PLANNING APPLICATION REPORT

REF NO: B/21/11/

LOCATION: The Stables
Burpham

PROPOSAL: Change of hipped end to gable & 1no. proposed solar panel to roof. This application lies within the South Downs National Park Authority.

South West Elevation - Proposed

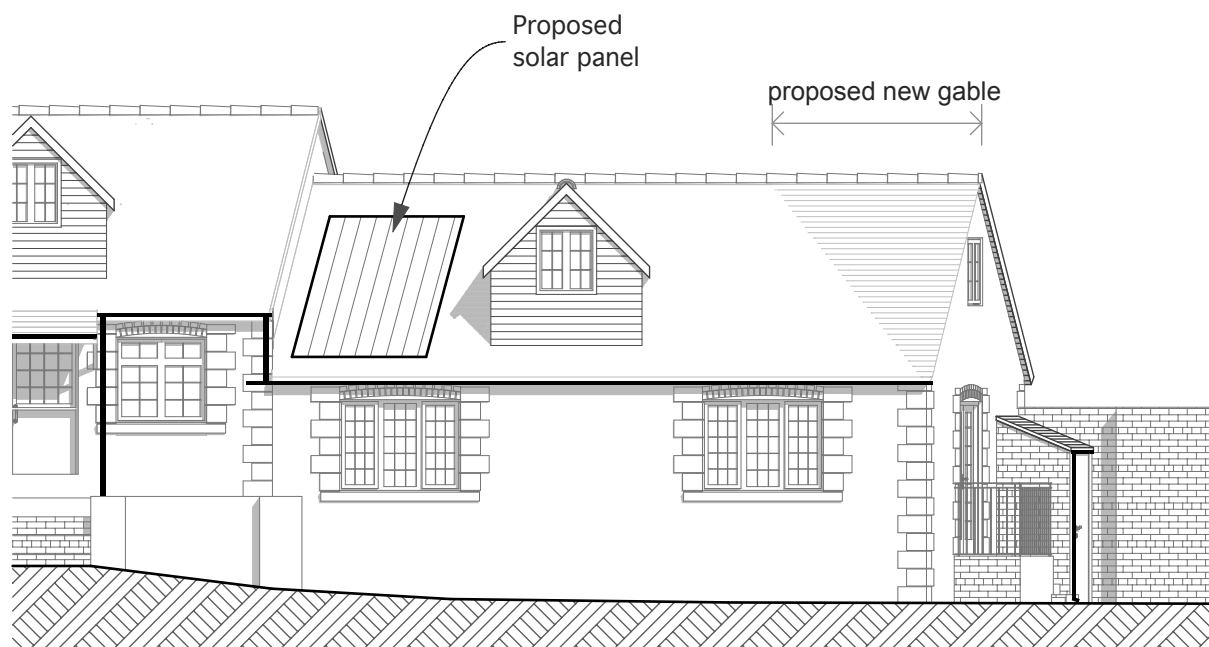
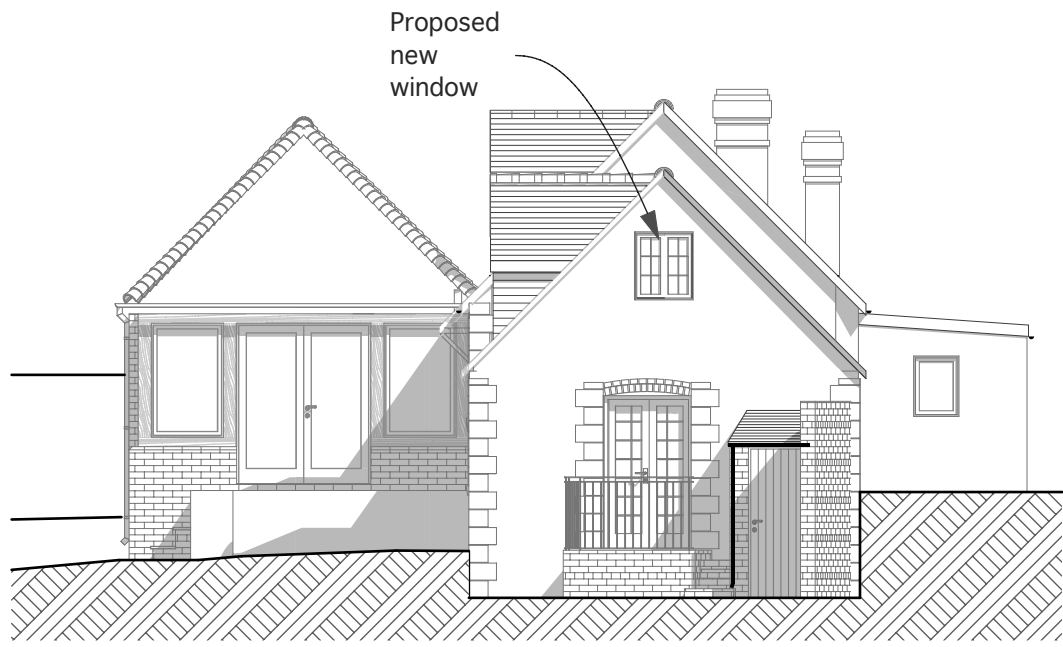
Objection; do not consider the solar panel installation enhances the Conservation Area.

Comments are noted, however the solar panels are sited to have a minimal impact upon the Conservation Area and would not be readily visible from the public domain given the screening provided by the dormer windows previously approved and the change in ridge height on the property. As such the proposal provides a sustainable energy resource which is considered to have a neutral impact upon the Conservation Area.

The proposed alteration to the rear roof slope to replace the hipped roof with a gable end is considered to enhance the appearance of the dwelling with no detriment to the character and appearance of the locality nor the amenity of neighbouring properties with the proposed window facing onto the paddocks/grazing land to the east of the site.

The introduction of the solar panel set between the step in the ridge line of the dwelling and the rearmost dormers provides for a sustainable energy resource in an acceptable position, mitigating any detrimental impacts upon the appearance of this historic Conservation Area.
